WEST SUSSEX COUNTY COUNCIL CONSULTATION

TO:	Arun District Council FAO:Simon Davis
FROM:	WSCC - Highways Authority
DATE:	23 December 2021
LOCATION:	253-255 Inglenook Hotel Pagham Road Pagham PO21 3QB
SUBJECT:	P/159/21/PL Variation and removal of conditions imposed under P/58/19/PL for the variation of condition 2-plans condition & 16-external lighting of roads & footpaths & removal of conditions 11-footpath access through Hotel site & 13-signage of vehicular access previously proposed.
DATE OF SITE VISIT:	n/a
RECOMMENDATION:	Advice
S106 CONTRIBUTION TOTAL:	n/a

Site Overview

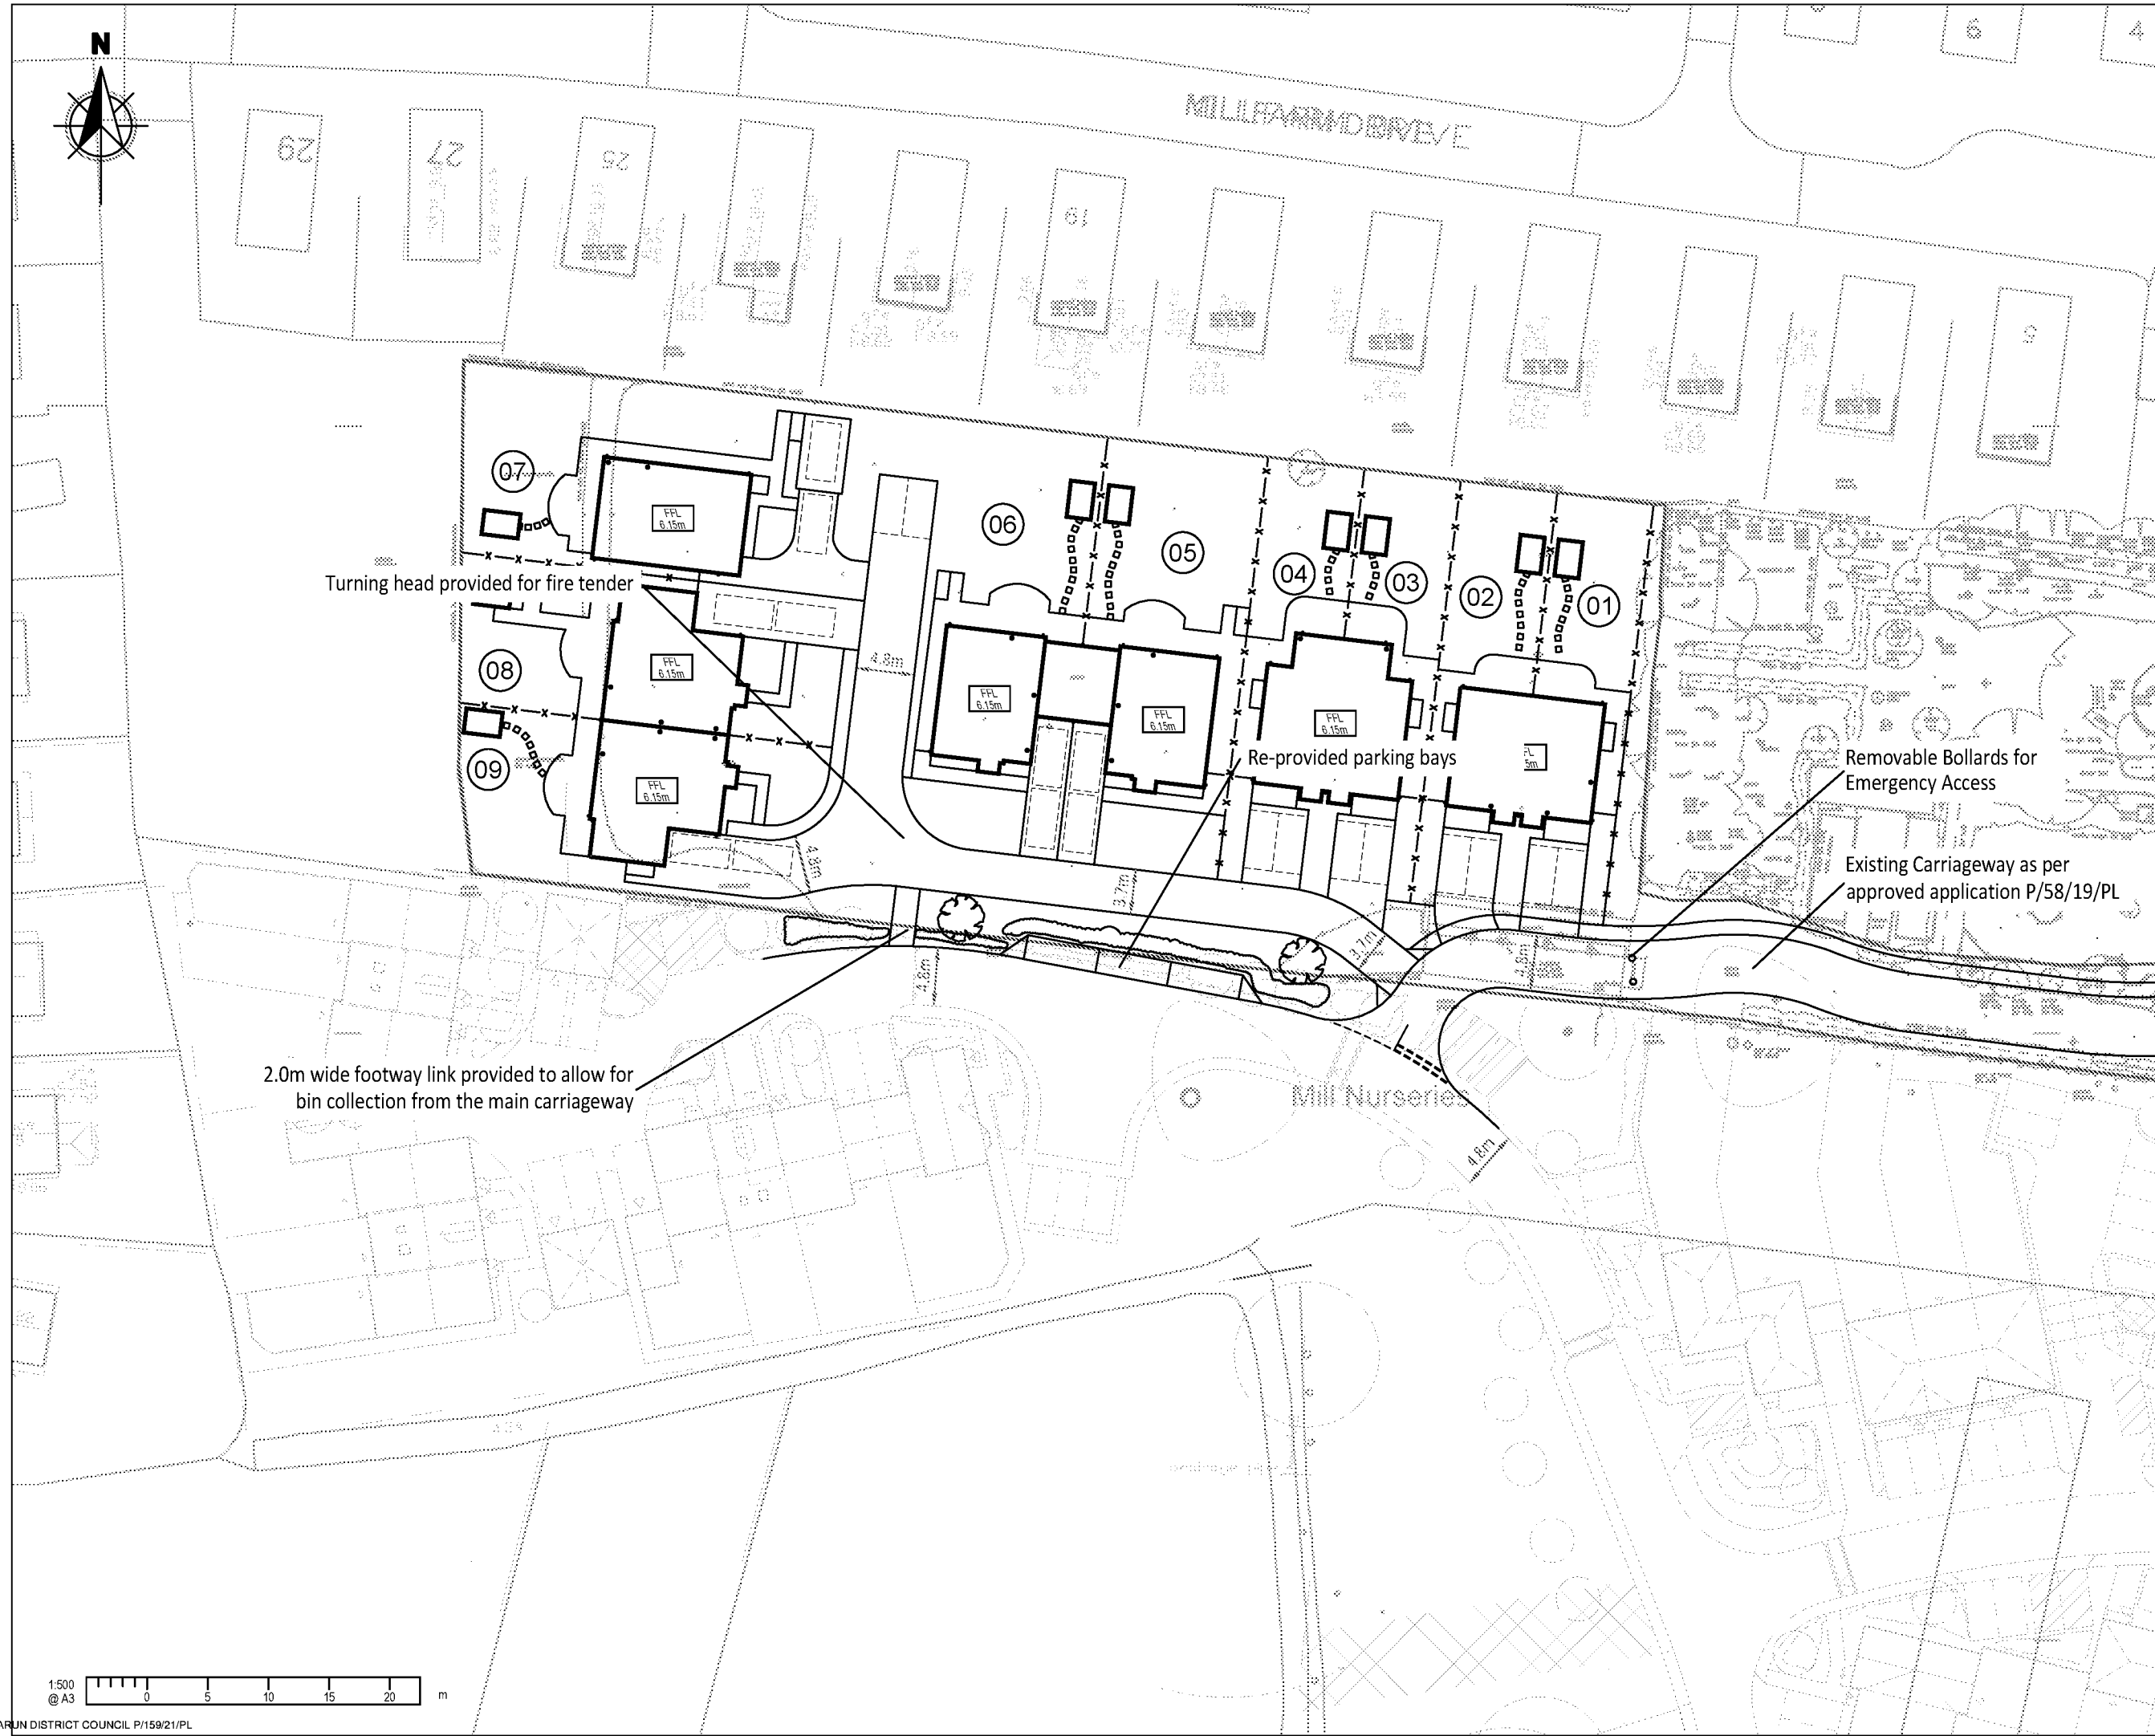
Pedestrian access would be via the existing network on Spinaker View. A 2.0 metre pedestrian link has been provided which would connect Spinaker View with the application site.

In principle the parking arrangements are as previously approved under P/58/19. Some changes have been incorporated in the form of the removal of 3 visitor parking bays which have been provided as parallel parking to the west of the site.

Access Overview and Visibility Splays

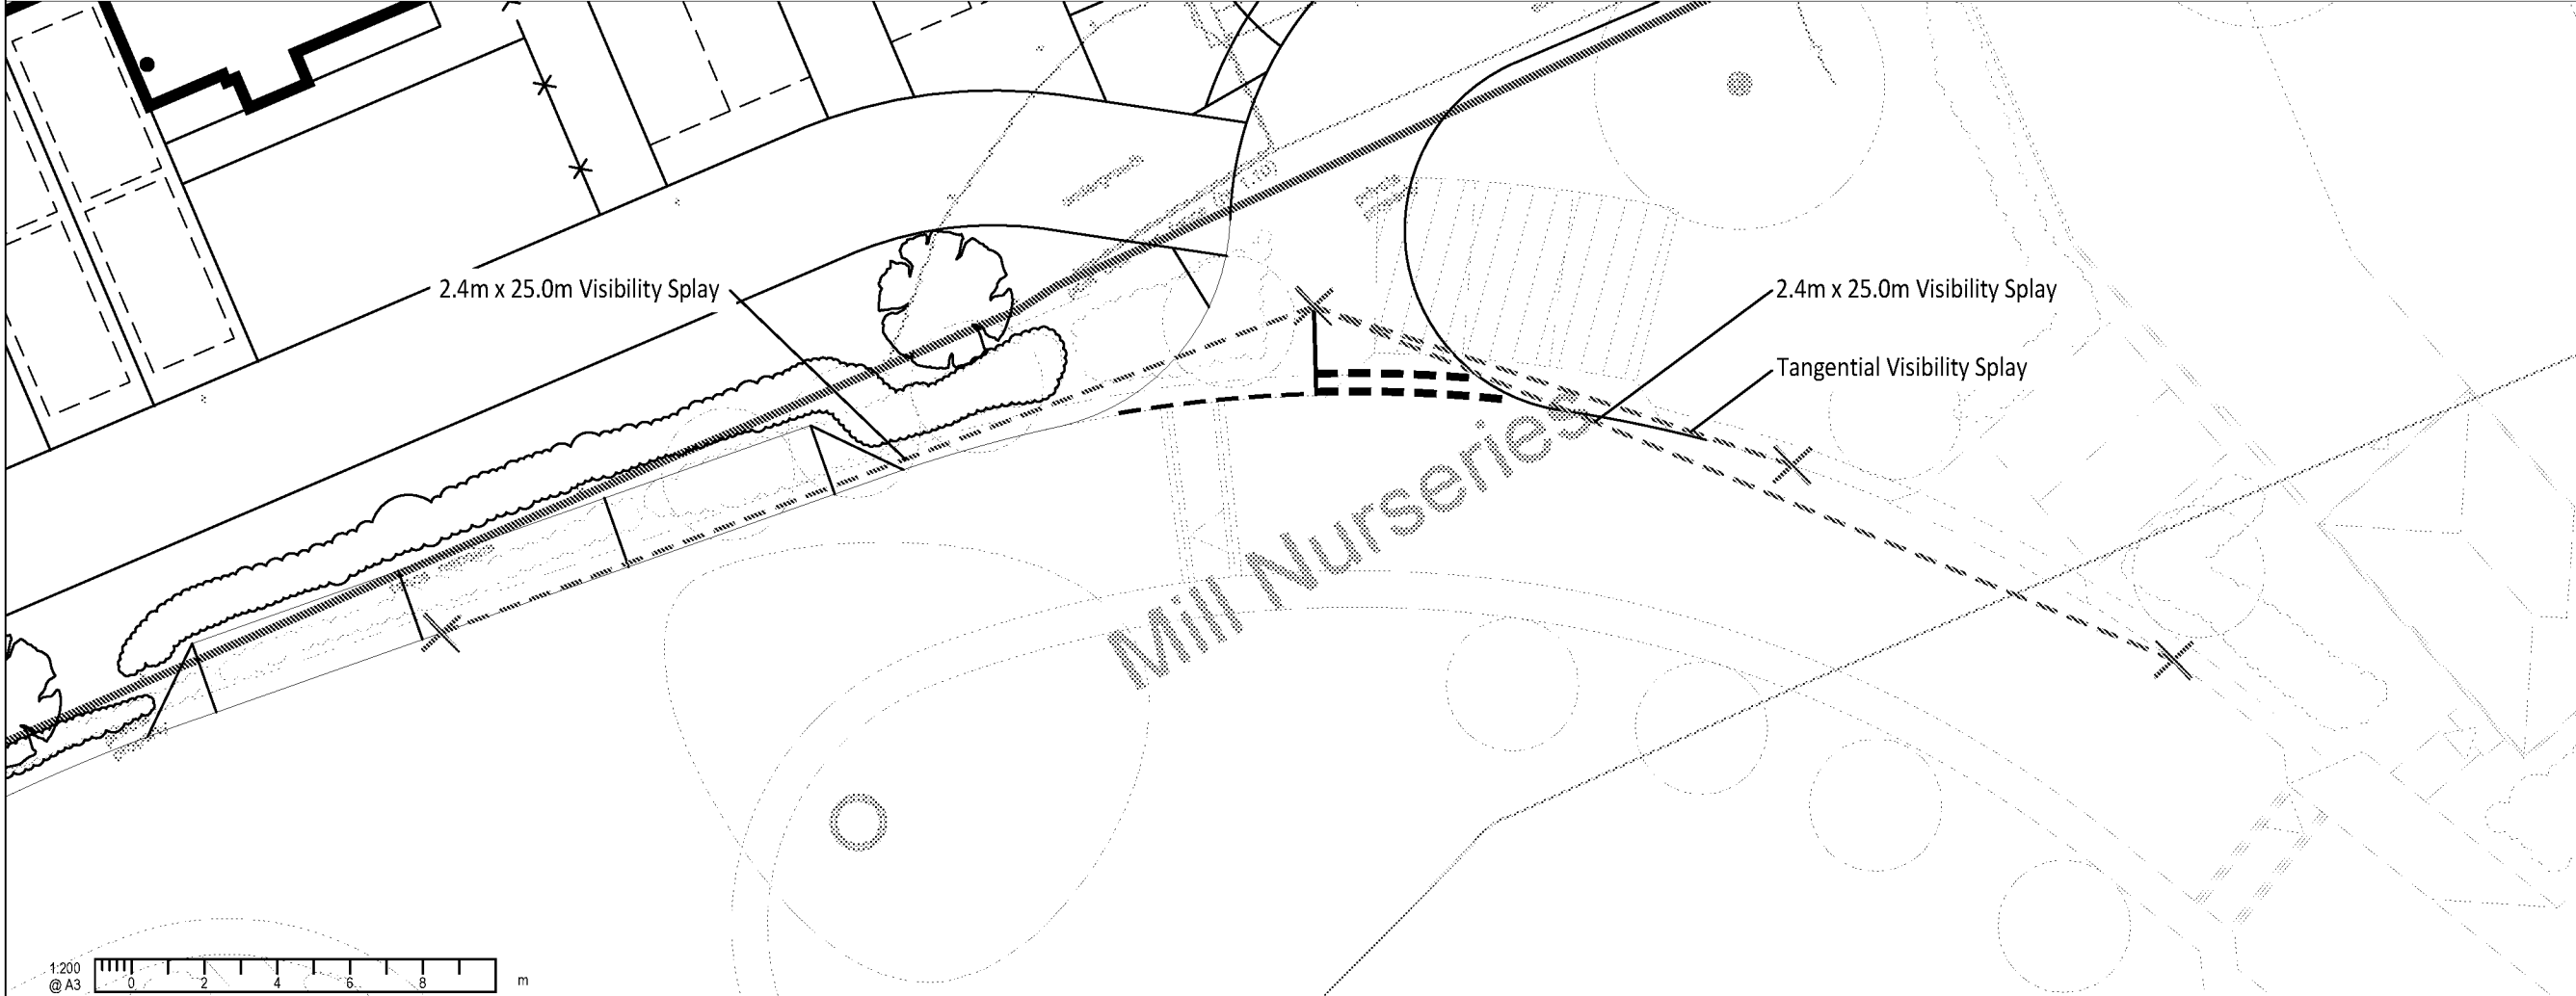
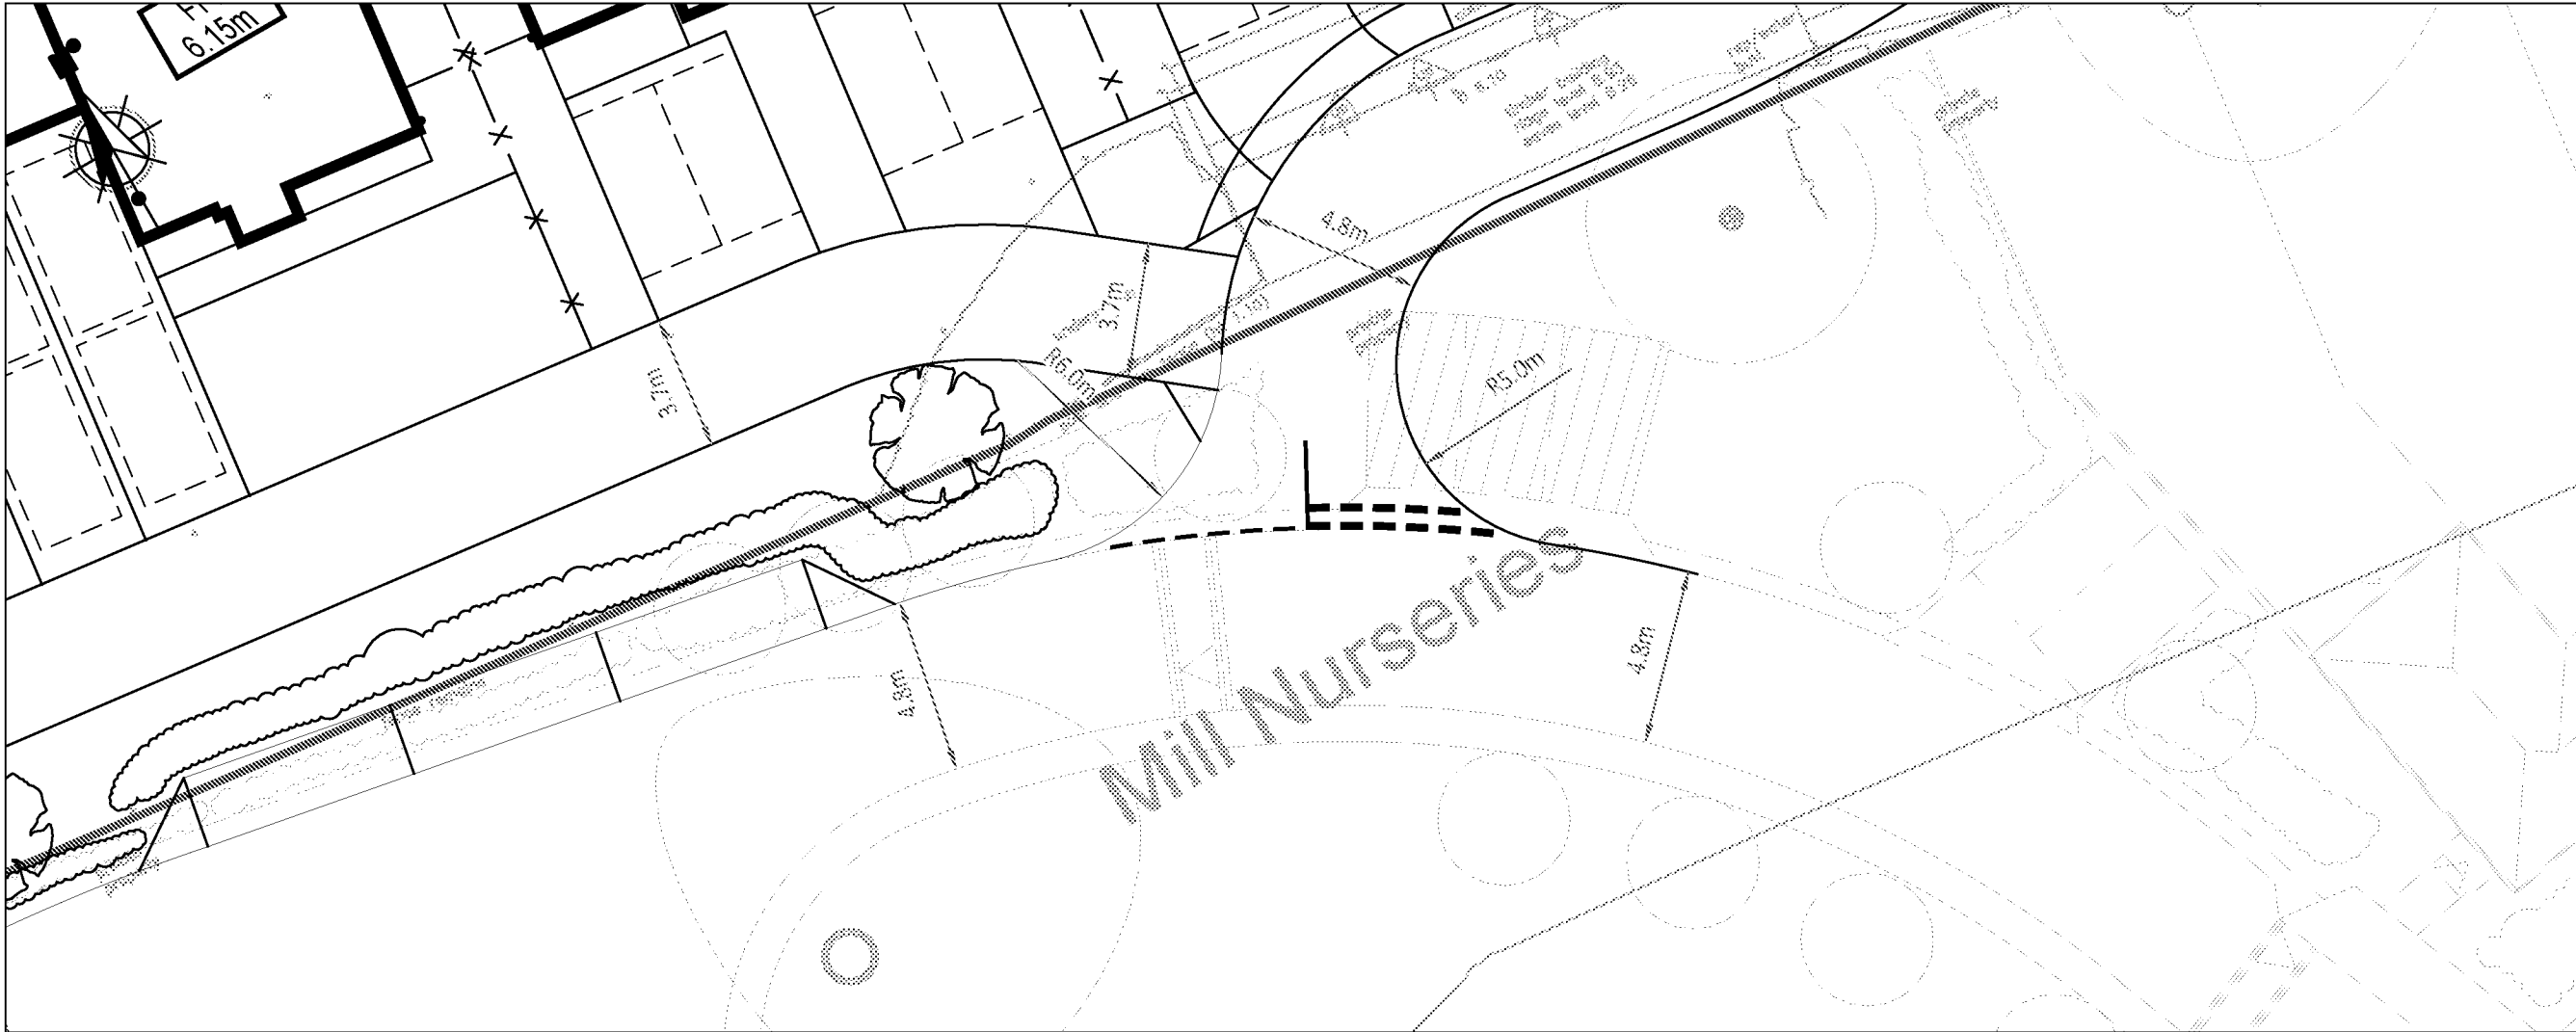
The access would take the form of a 4.8 metre wide bellmouth. This has been designed in accordance with design speeds from Manual for Streets (MfS) of 20 mph with visibility splays provided at 25 metres from the point of access, the LHA would concur that MfS guidance is acceptable in this context. Visibility from Spinaker View onto Pagham Road has not been assessed within the TN however having assessed the junction it would appear that sufficient visibility is available in both directions. A review of the access shows at the time of writing that there have not been any recorded Road Traffic Collisions within the vicinity of the existing junction.
